## KITTITAS COUNTY COMMUNITY DEVELOPMENT SERVICES

September 9, 2019

RE: Rampart Row Short Plat, SP-19-00002

The comment period for the Rampart Row Preliminary Short Plat, SP-19-00002 ended on Friday, September 6, 2019 at 5:00 pm. Community Development Services received the following public comments:

RAMPART ROW SHORT PLAT APPLICATION

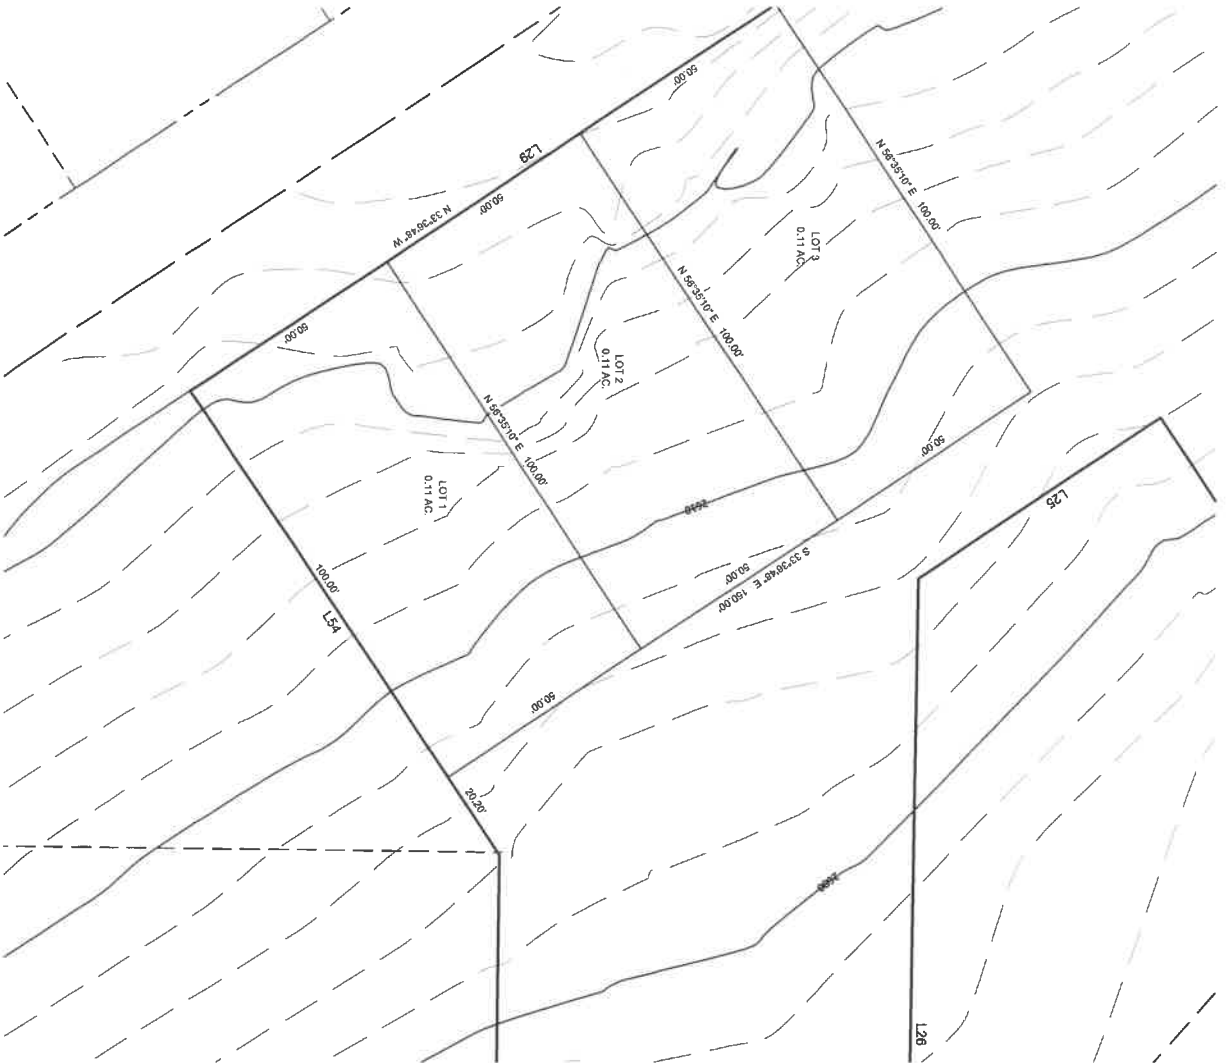
1. Address the new requirements of WAC 332-130-145.
2. The two labels for Lot 4 should be labeled as "part of" or "portion of", so as not to appear to be two separate Lots.
3. The Parking Lot Easement should clarify if it is existing, dedicated, or to be created via separate document.

While not required for the preliminary, it appears that there appears to be a trespass, encroachment, or usage outside of the easement near the line labeled as L33. This should be identified on the final.
